From: Katherine Rawlins
Sent: 04 January 2012 13:08
To: 'chris'
Subject: BR/294/11/ 6-8 London Road
Dear Mr Moore,

With reference to the above application, I have carried out a site visit and have no concerns regarding the principle of the change of use to A3 coffee shop and ancillary retail. The site is located within the primary shopping frontage and is surrounded on both side by retail units.

PROPOSED GROUND FLOOR PLAN

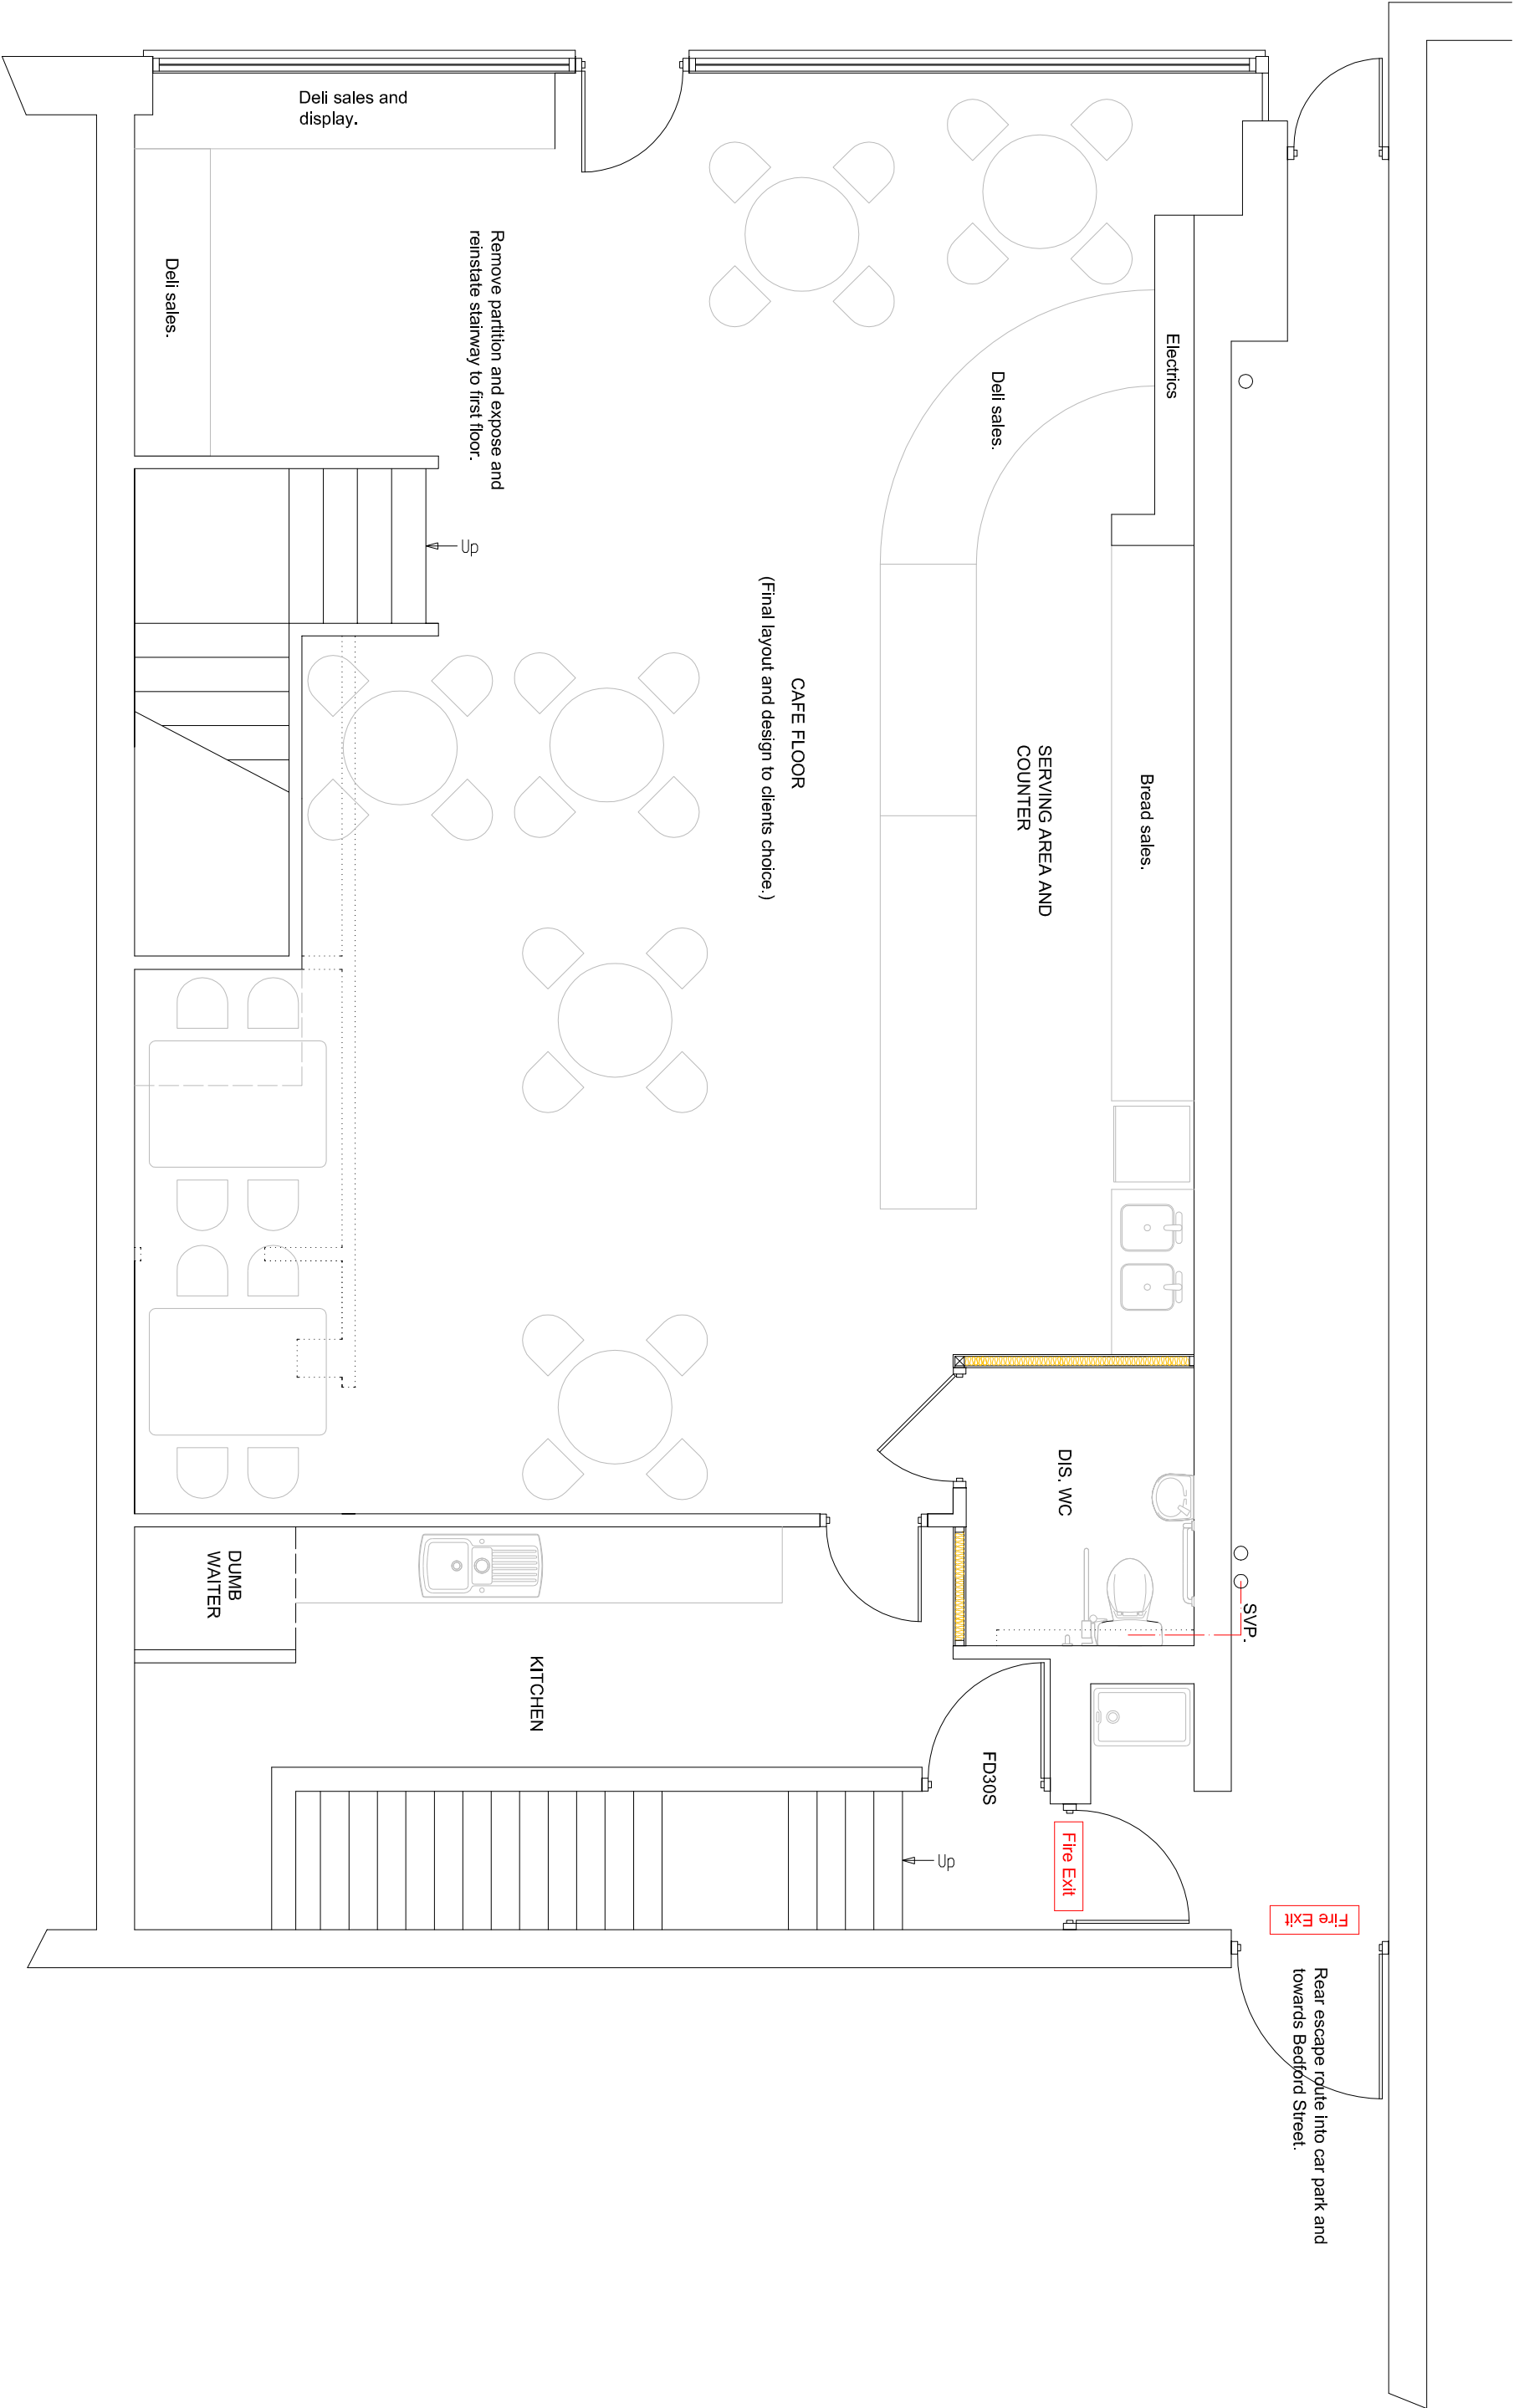
However, Environmental Health Officers have raised concerns regarding the location of the disabled WC, which is close to the servery area and the kitchen door with no intervening lobby. The toilet should be re-located as this area is a potential busy traffic area for customers and staff particularly from the kitchen and from customers queuing. It also opens out into an area where food is handled. In addition, it is not clear on the plans where the food will be stored (on the original plans there is a large storage room on the first floor).
